## Rezoning Petition Review

**Date of Review:** September 24, 2020 (**Revised November 30, 2020**)

**Rezoning Petition #:** 20-122

**Location of Property:** Approximately 50.03 acres located along the north side of Hucks Rd, along the east side of Arthur Davis Rd and south of I-485.

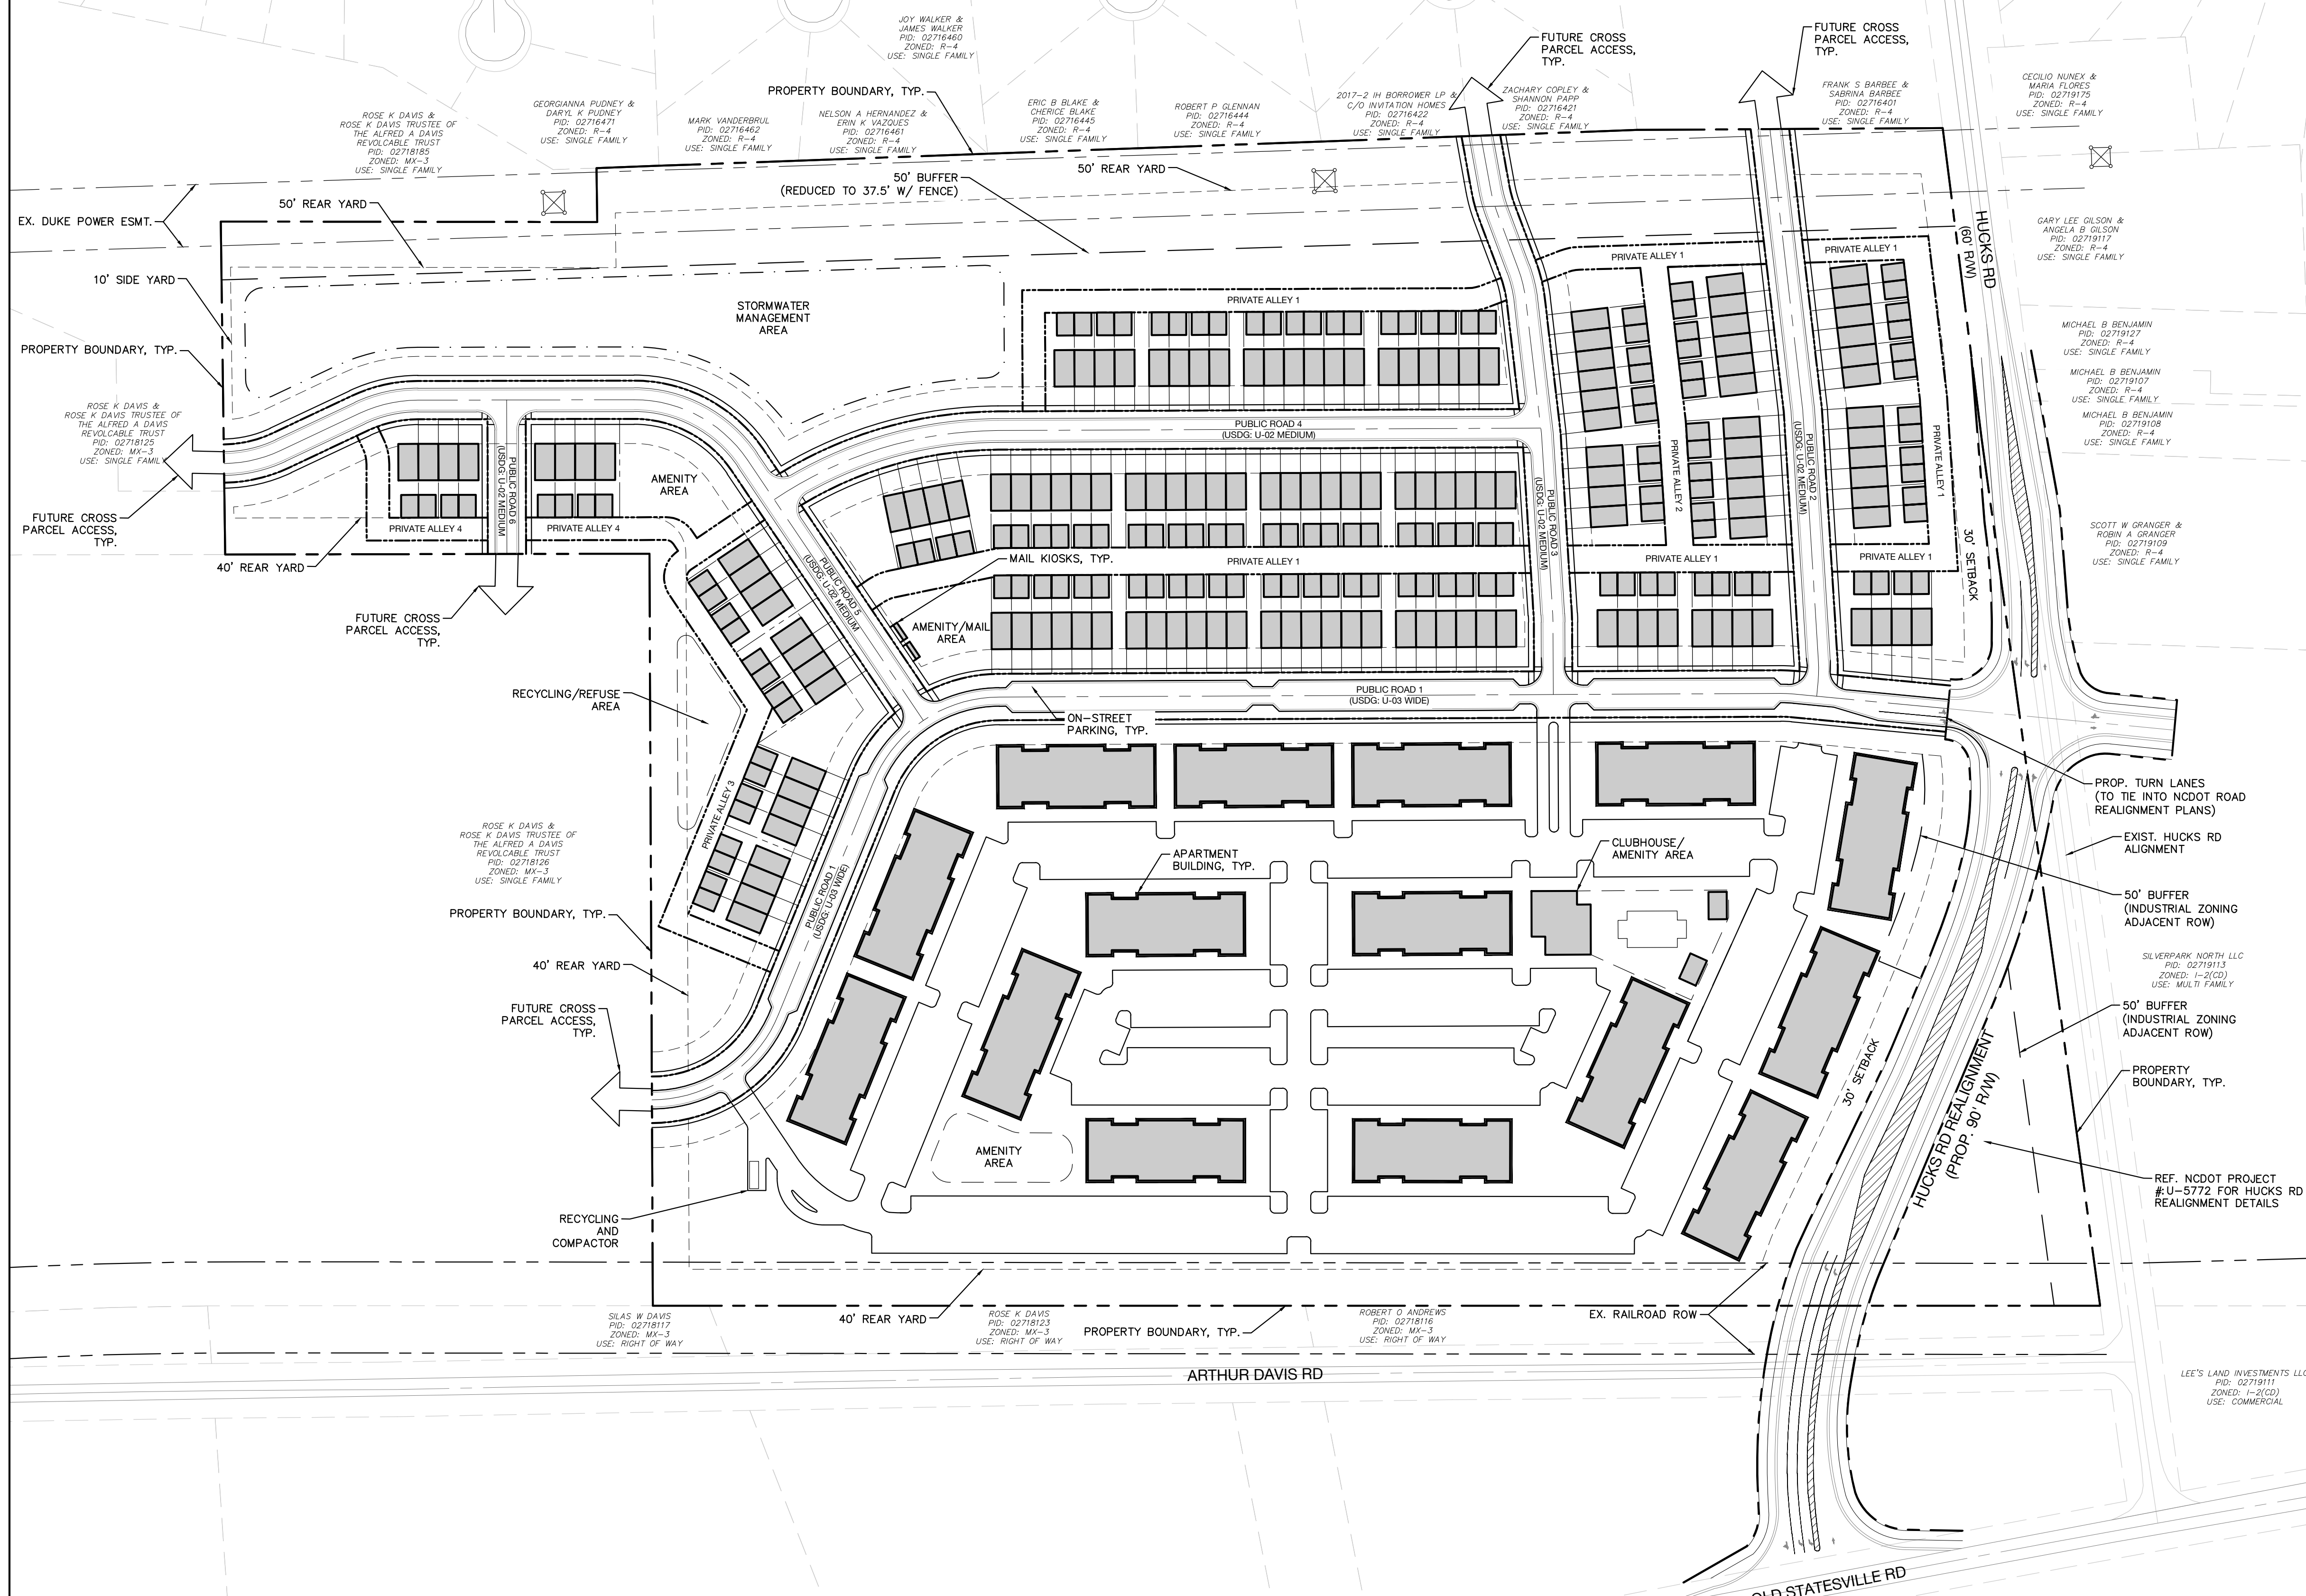
City of Charlotte GIS data indicates a 100-ft Undisturbed PCSO buffer across the site. Please show and label *Potential 100-ft Undisturbed PCSO Buffer* on the site plan. Please note additional SWIM/PCSO Buffers may extend around the existing pond on site. Any increase of impervious area within such buffers may not be allowed and is not approved with the rezoning process. Stream Delineation Reports are subject to review and approval by Charlotte Storm Water Services. Please include the following note under Environmental Features: *“Development within any SWIM/PCSO Buffer shall be coordinated with and subject to approval by Charlotte-Mecklenburg Storm Water Services and mitigated if required by City ordinance. Petitioner acknowledges intermittent/perennial stream delineation reports are subject to review and approval upon submission of development plans for permitting and are not approved with rezoning decisions.”*
